Approval of details reserved by condition imposed under ref CM/23/18/L relating to Condition No 2 - external cladding.

Clymping Mill Climping Street Climping BN17 5RN

MILL COTTAGE CLADDING DETAIL
SECTION THRU' EAVES AND WINDOW
SCALE 1:5

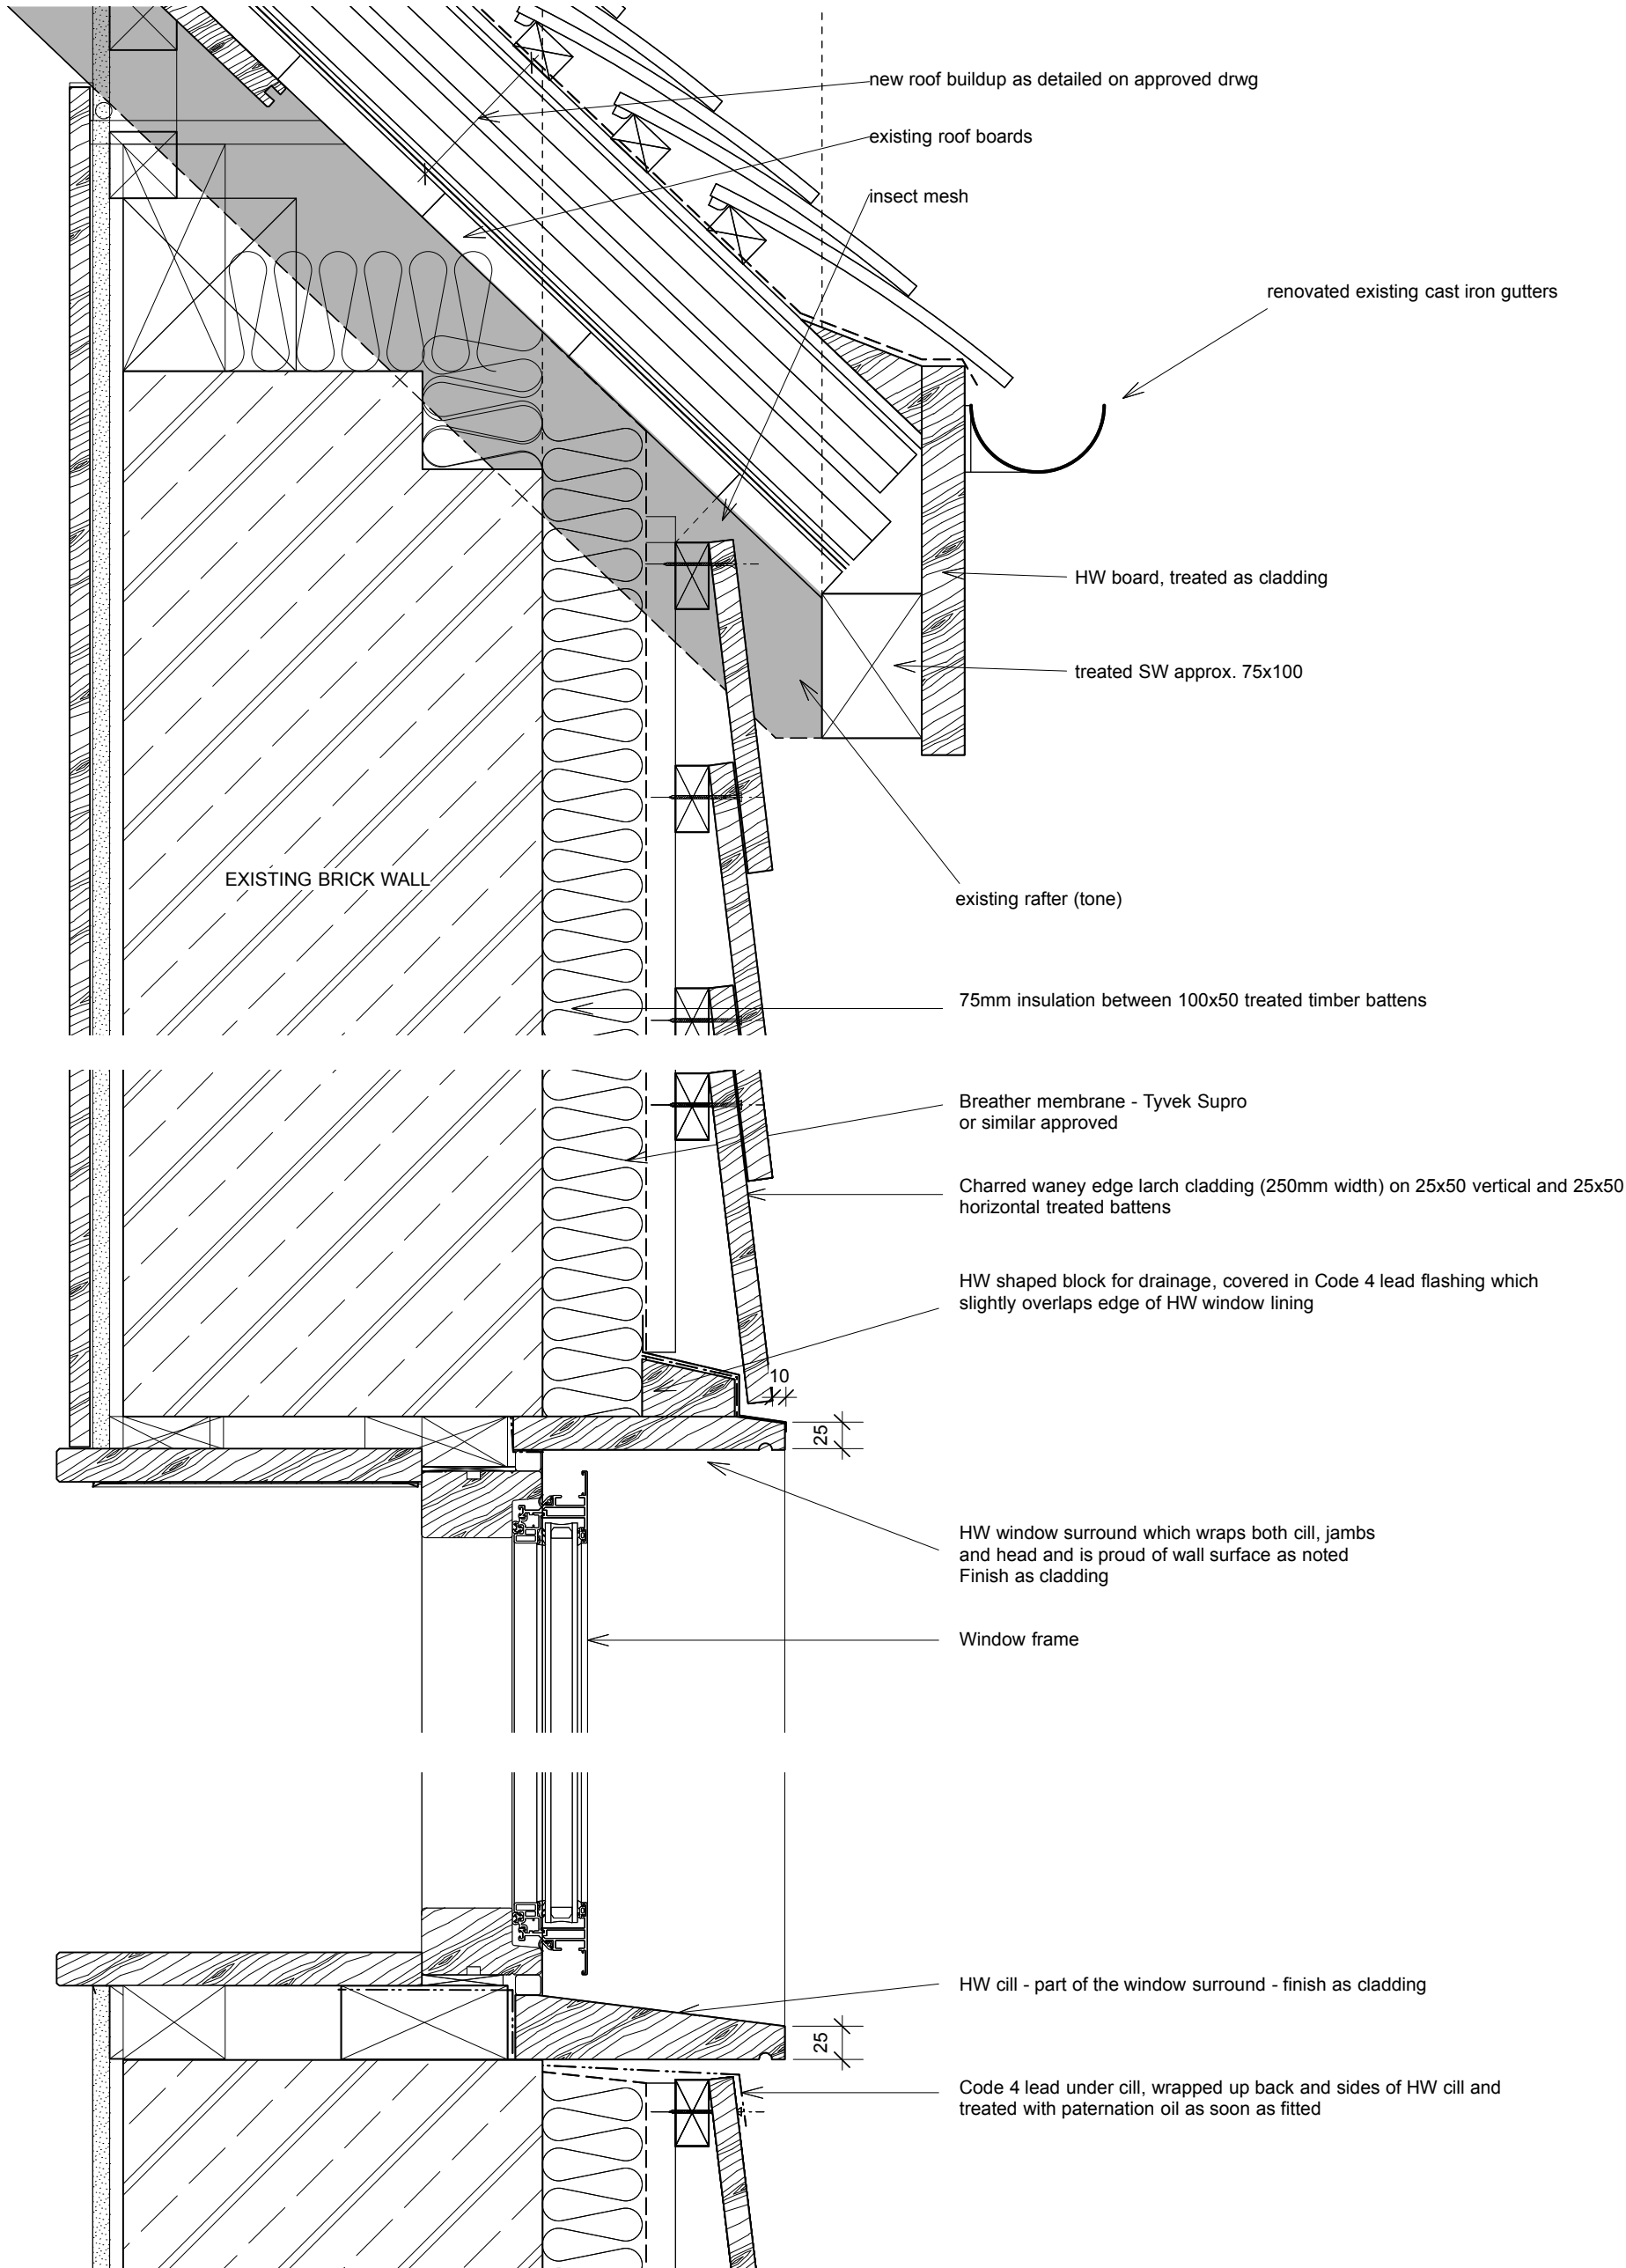
This condition is discharged in so far as submission of details relates and refers to the section details on drawing 04 001_2 and the material submitted to these offices on 16/04/2019. Namely larch waney-edge shiplap board, lapped to create 250mm board widths, with a double charred finish.
